WILPSHIRE PARISH COUNCIL

9 October 2012

3/2012/0760 Creation of additional parking at The Homestead, Whalley Road,
Wilpshire

PROPOSED SITE PLAN - SCALE 1:200

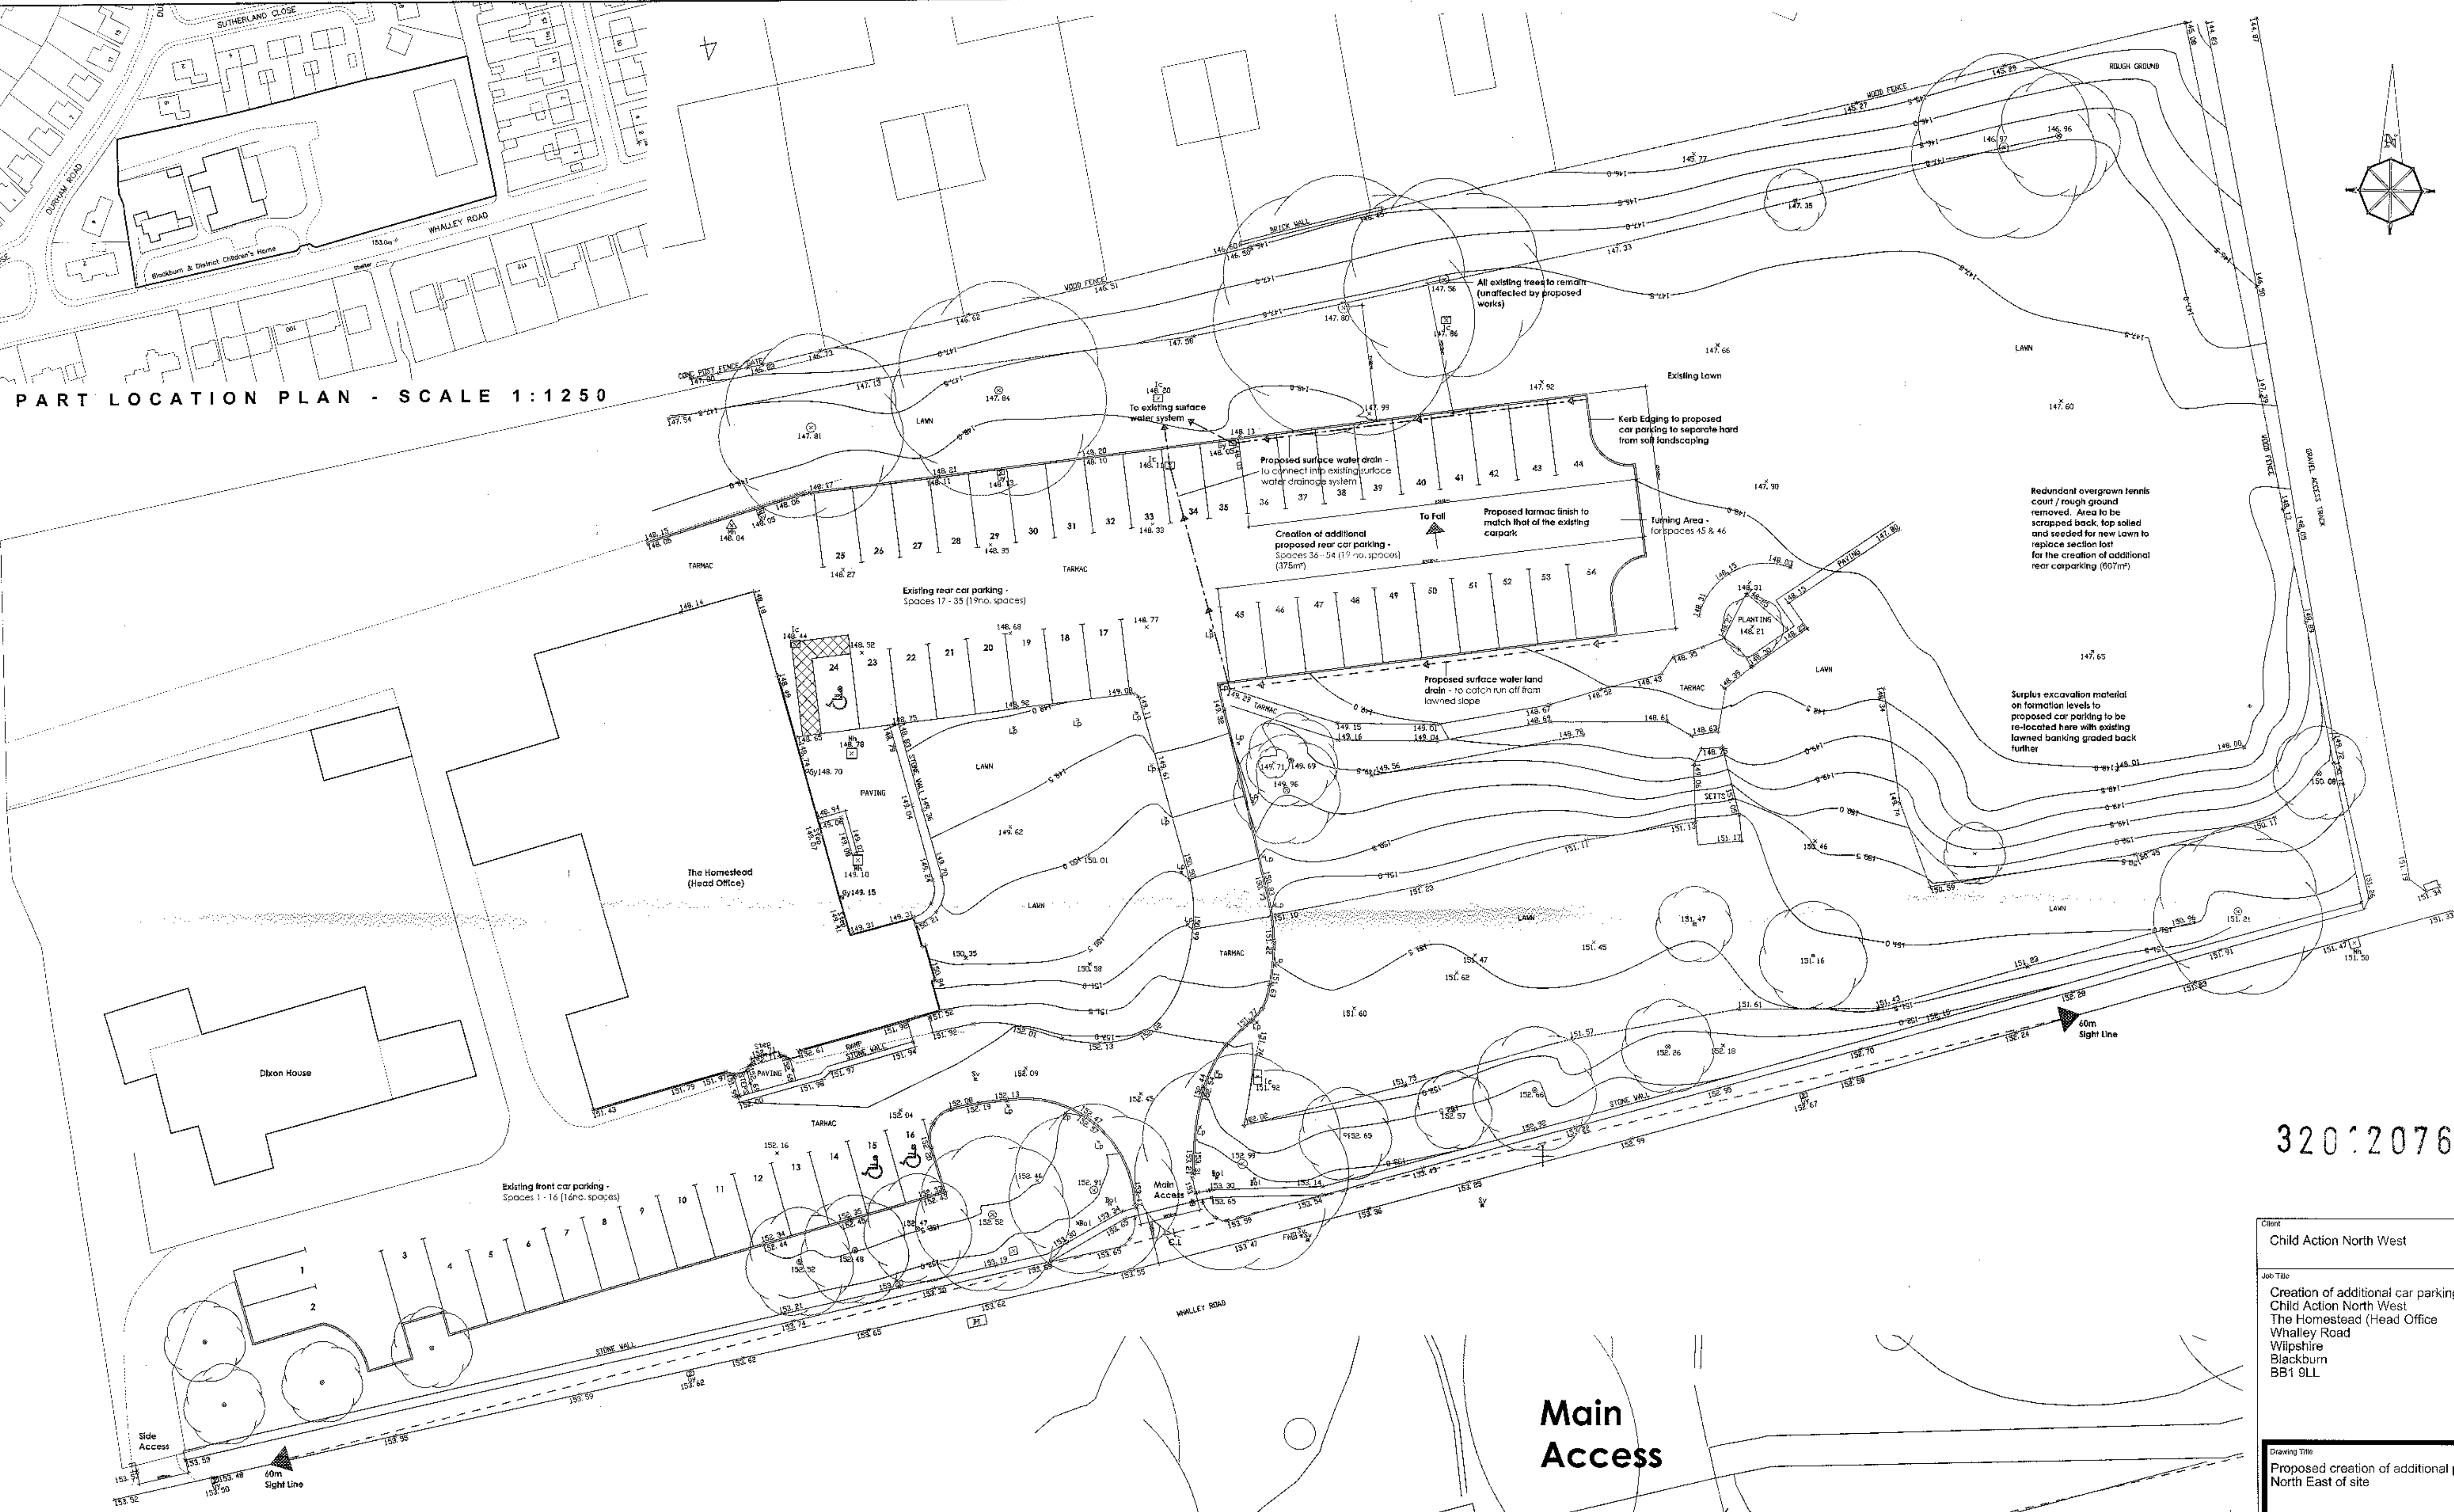
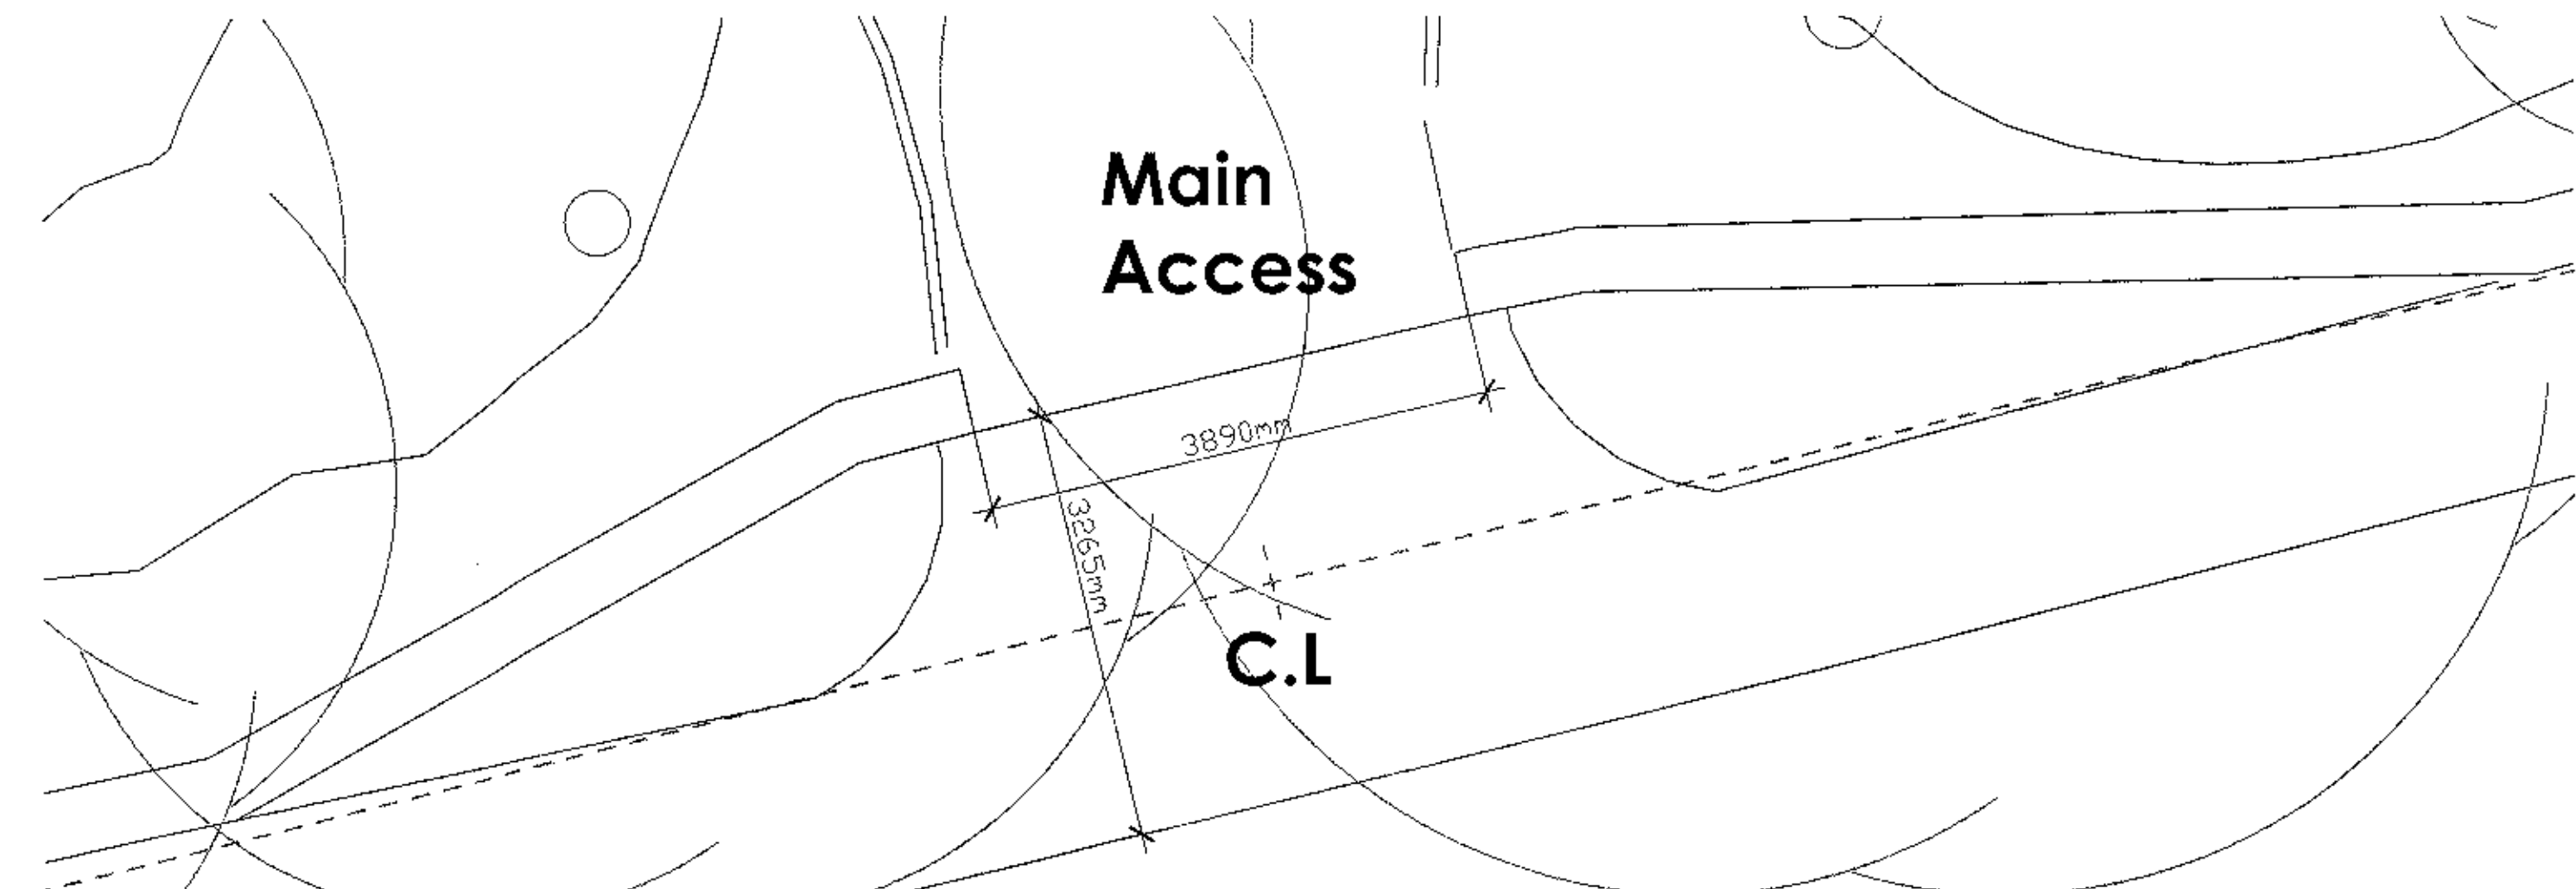
Wilpshire Parish Council would ask that adequate drainage facilities be ensured for
the large area of hard surface.
